Our reference: P-710411-R7L5
Contact: Sandra Fagan
Telephone: (02) 4732 7992

2 July 2024

Council Response to SSD-10479-Mod-2 - Modification 2 to 200 Aldington Road Industrial Estate (AIE) at 106-228 Aldington Road, Kemps Creek, NSW, 2178

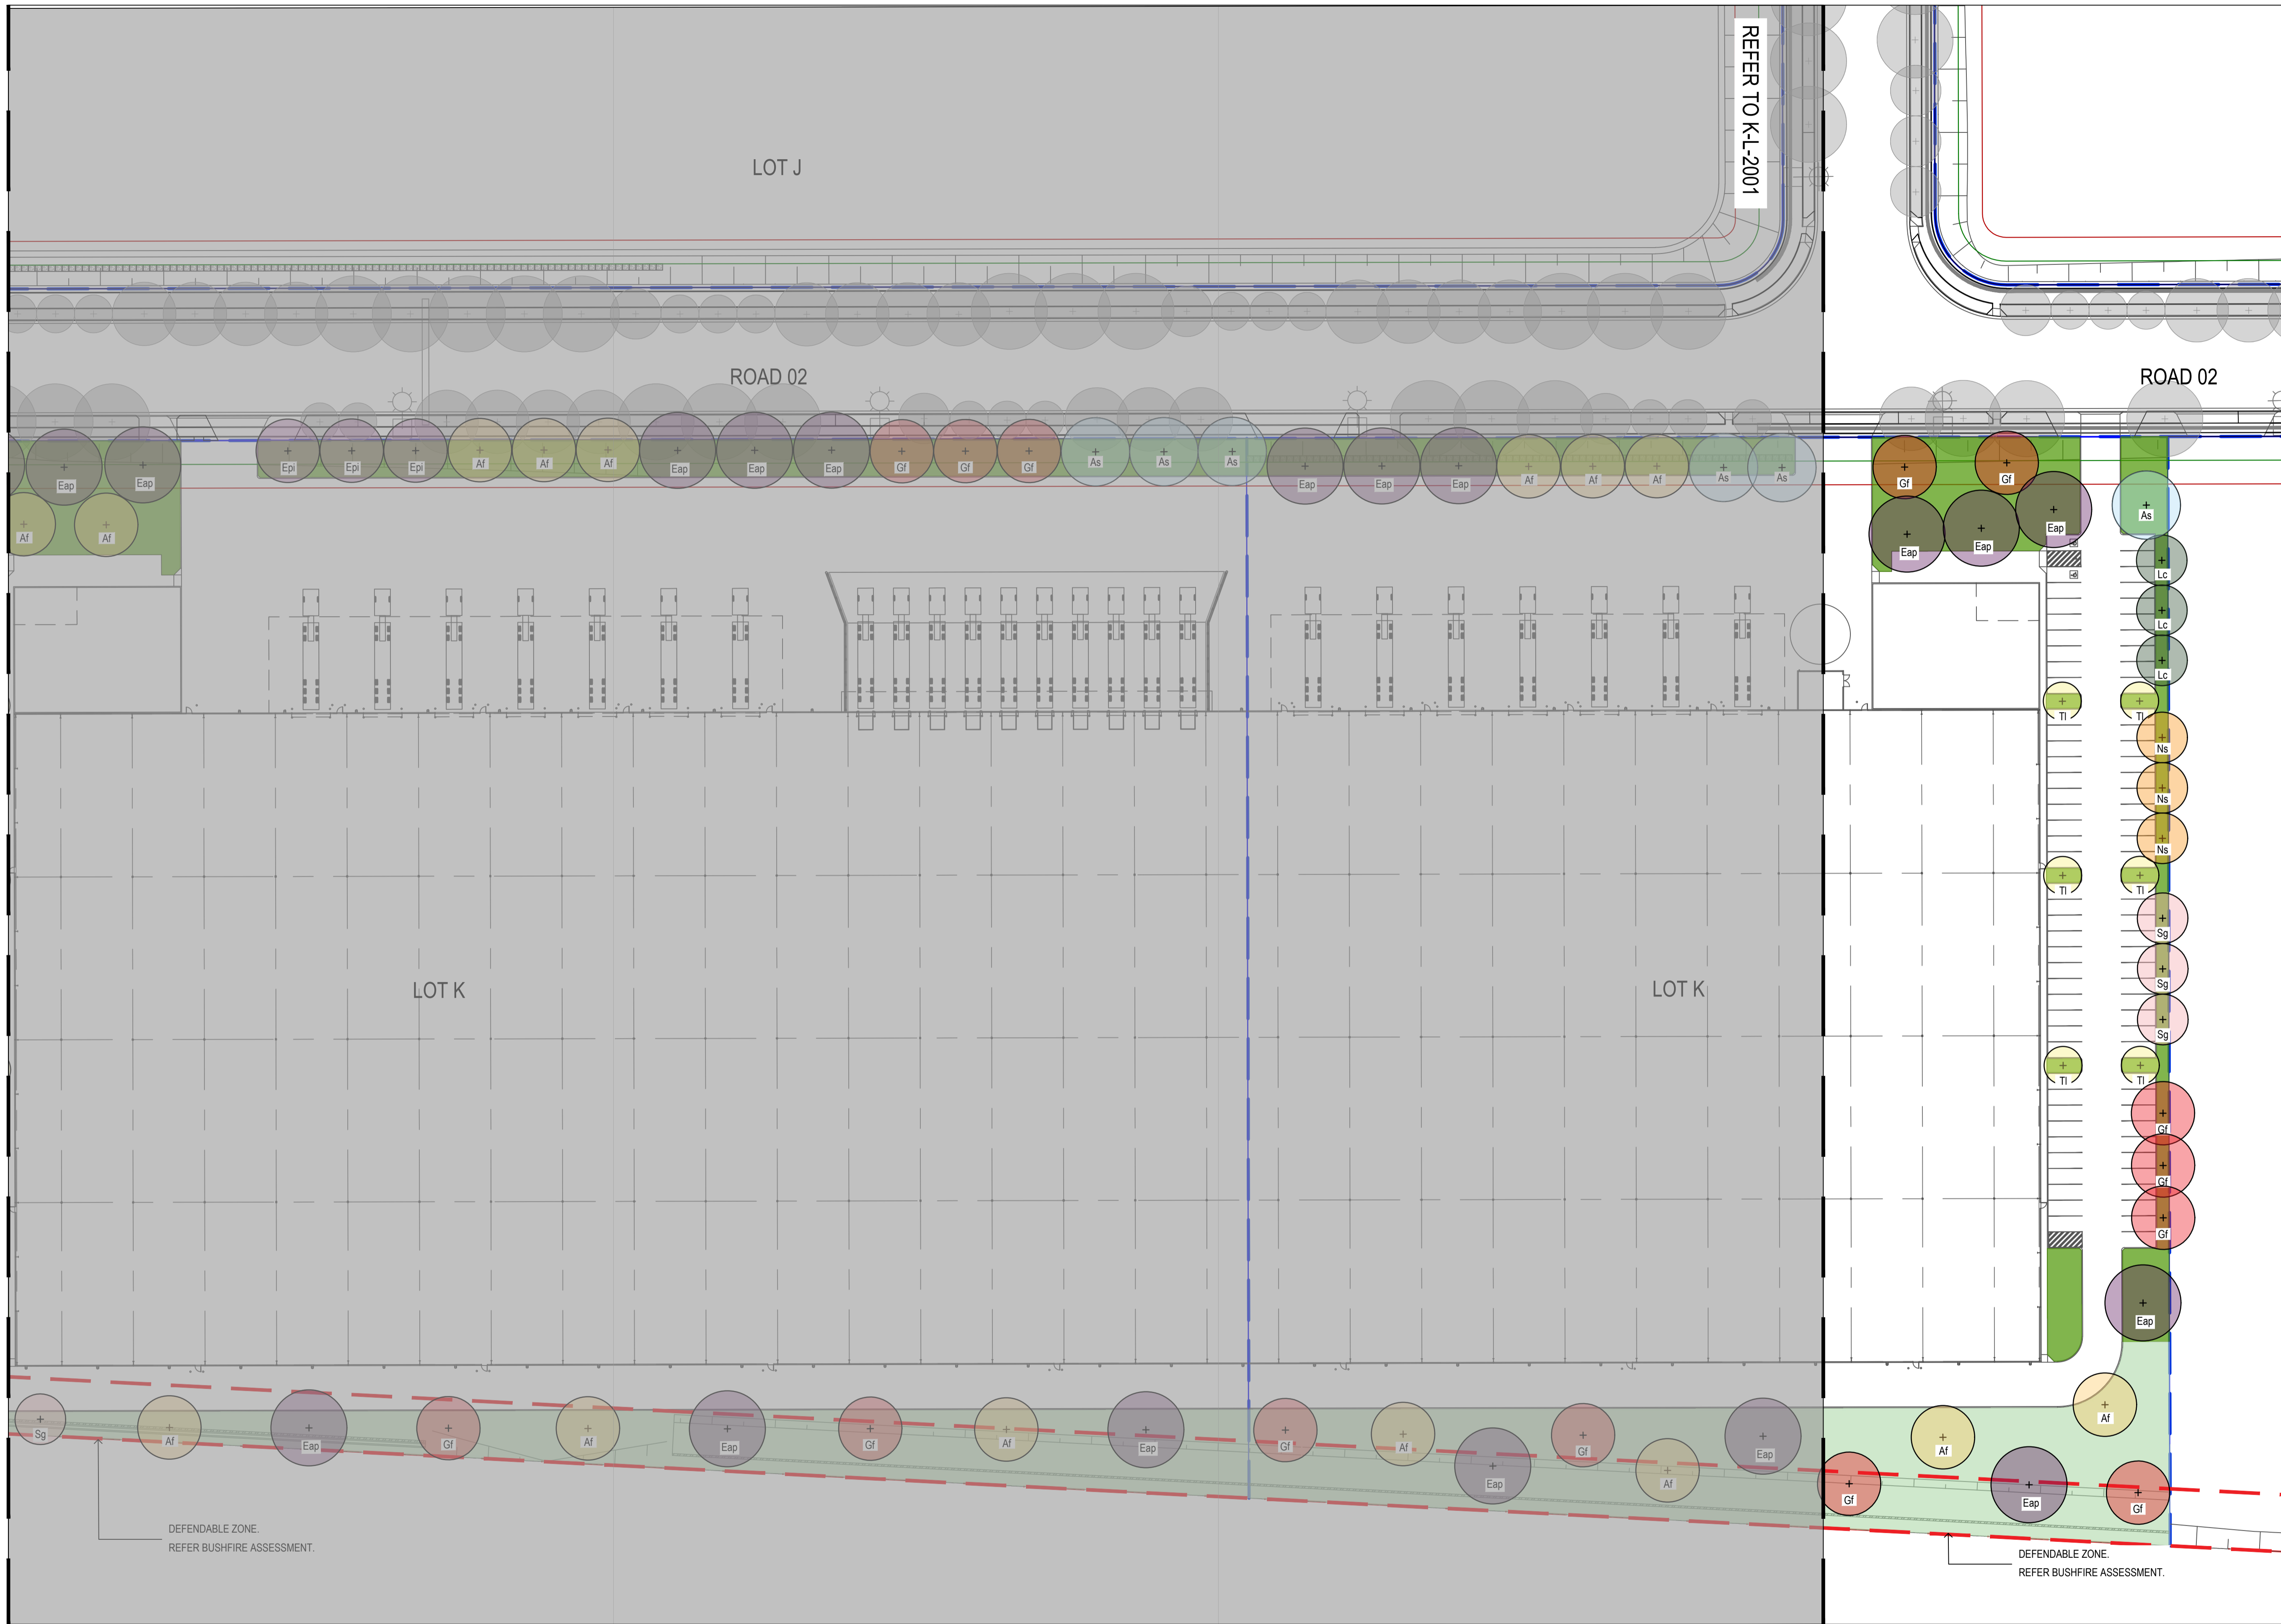
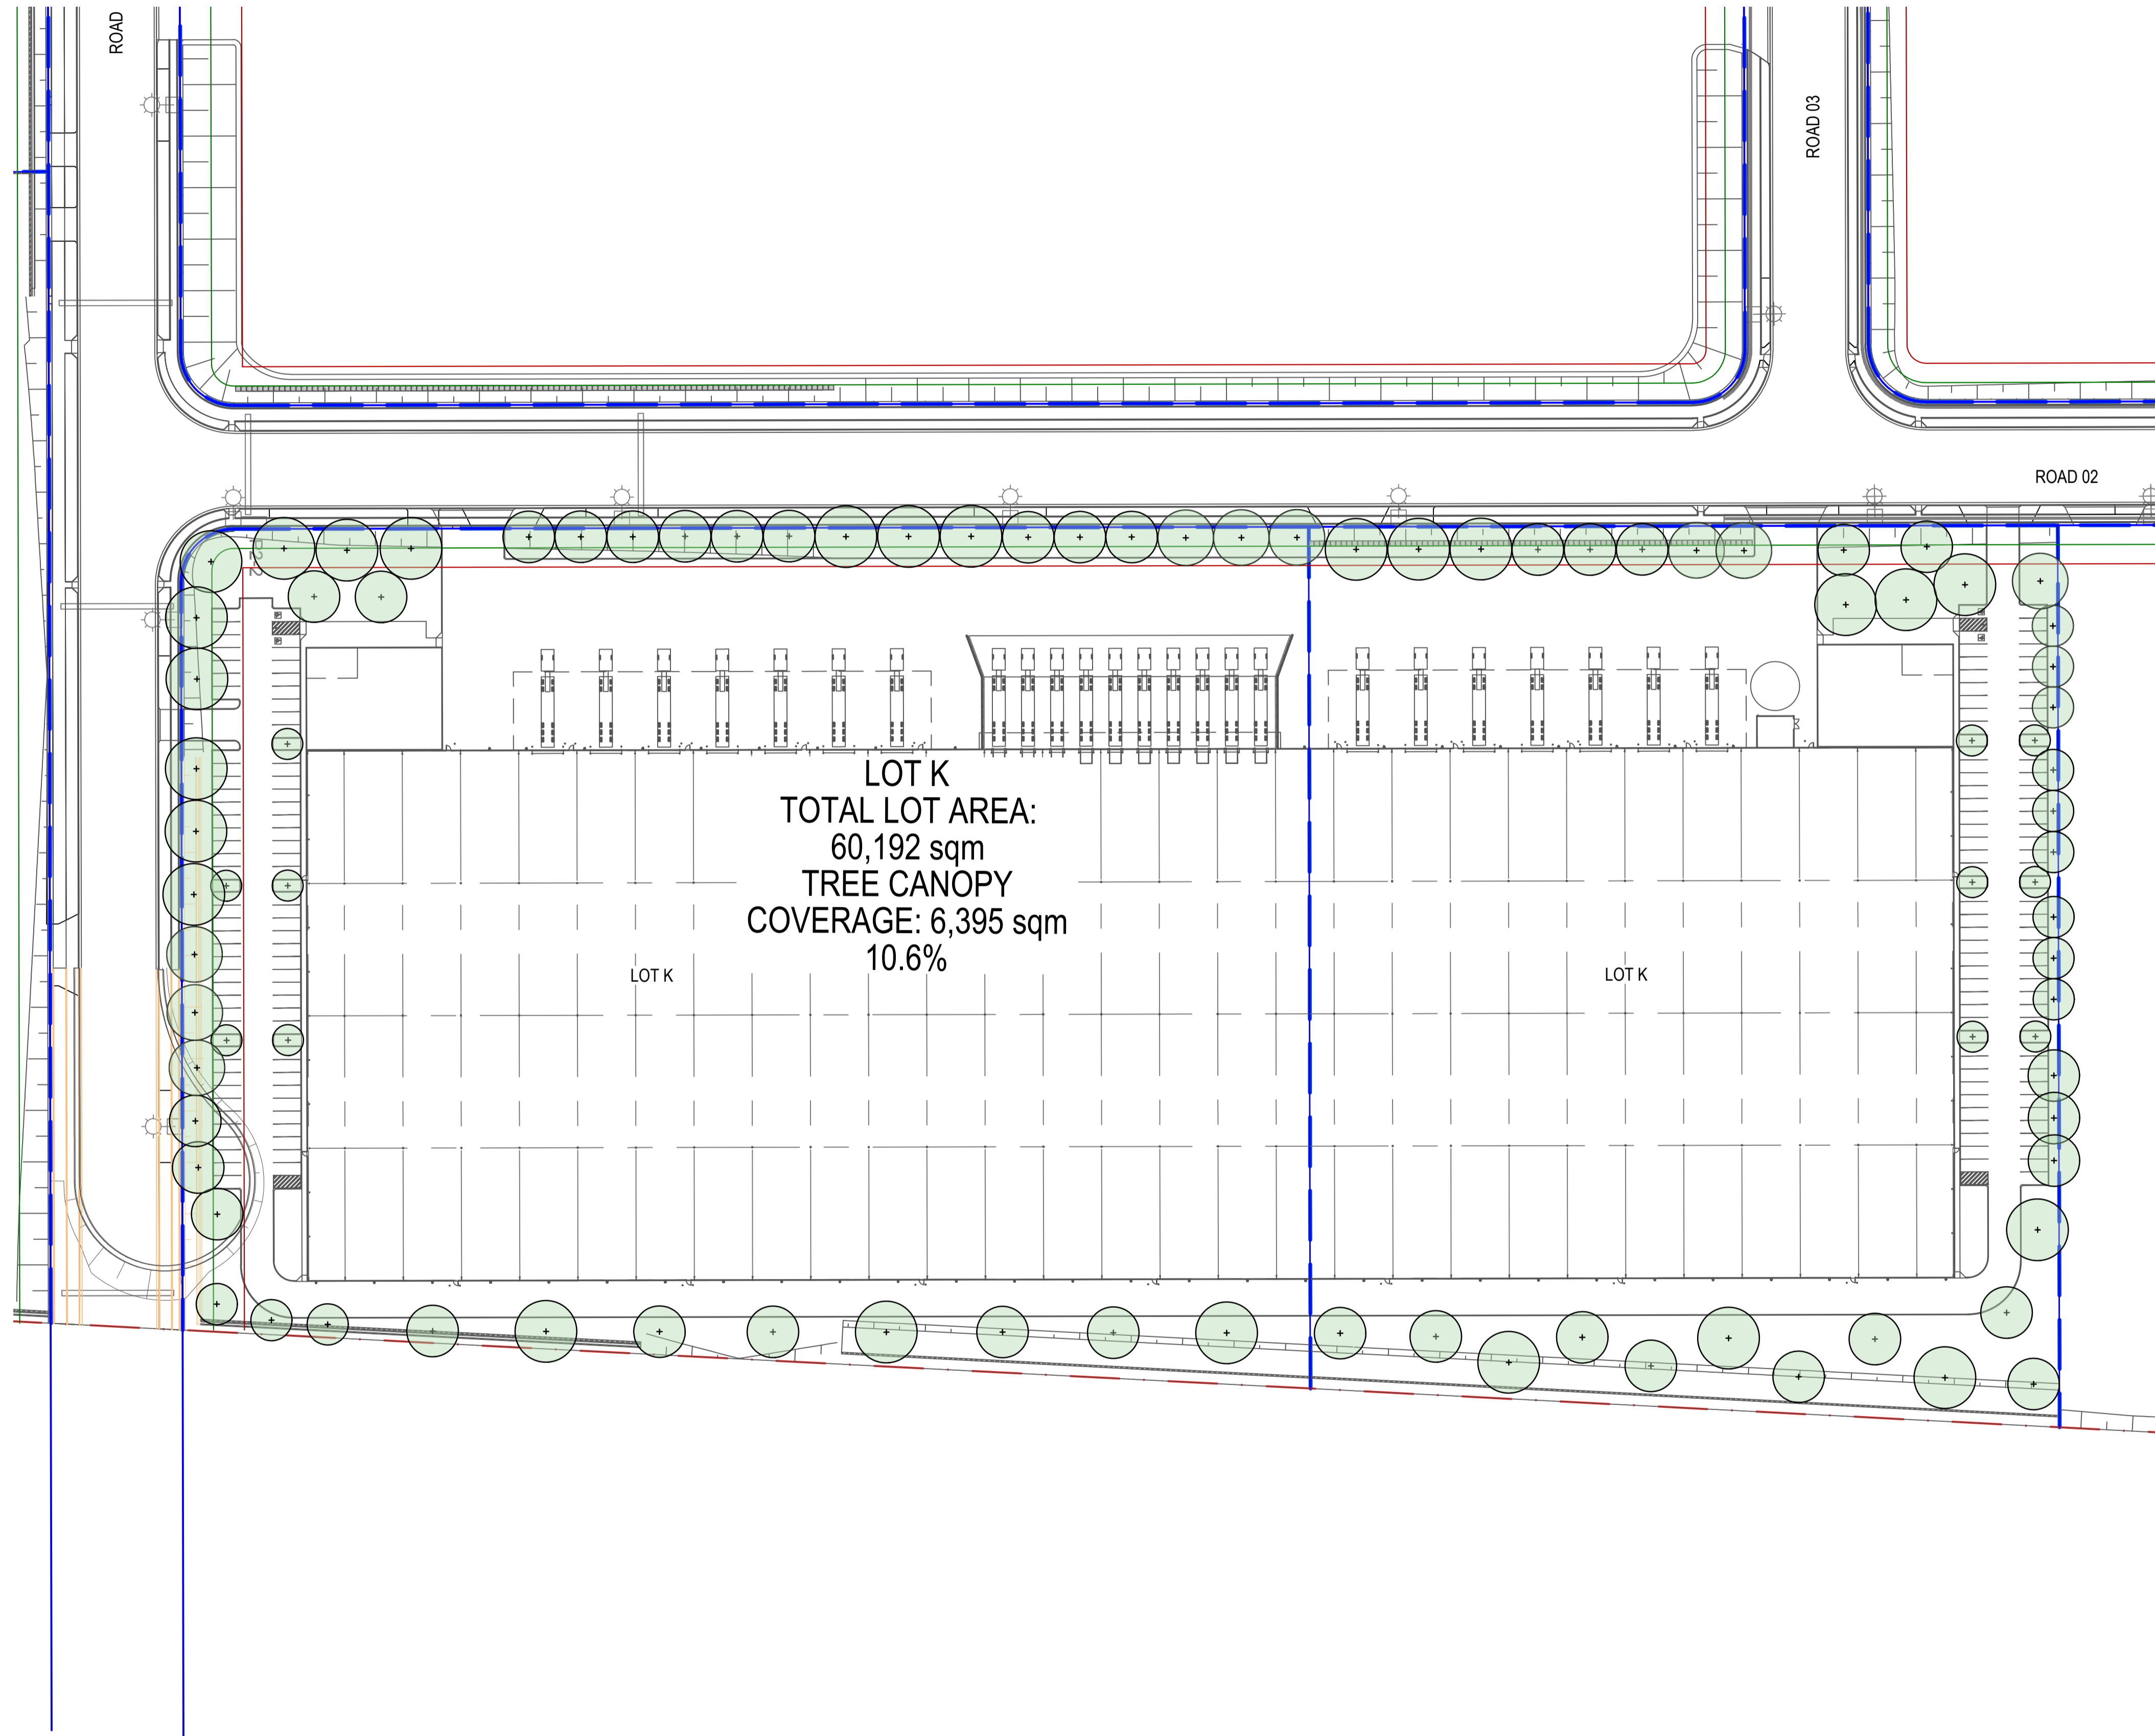
- a) The species selection for street trees shall be in accordance with Council's Draft Street Tree Masterplan. This includes:
 - i. For the eastern side of Aldington Road, this is to be *Lophostemon confertus* (Brushbox).

- ii. For the collector road running east-west (at the southern end of the estate), this is to be *Angophora Floribunda* on both sides.
 - iii. For the collector road running east-west (at the northern end of the estate), this is to be *Angophora Subvelutina* on both sides.

- iv. For the local industrial road running north-south through the site, this is to be *Waterhousia floribunda* on both sides.
 - v. For other minor internal estate roads, select from the following:

c) The proposed shrubs and mass plantings within the future public verges (below the street trees) shall be replaced with turf. Mass plantings below trees on private land is supported and should be retained.
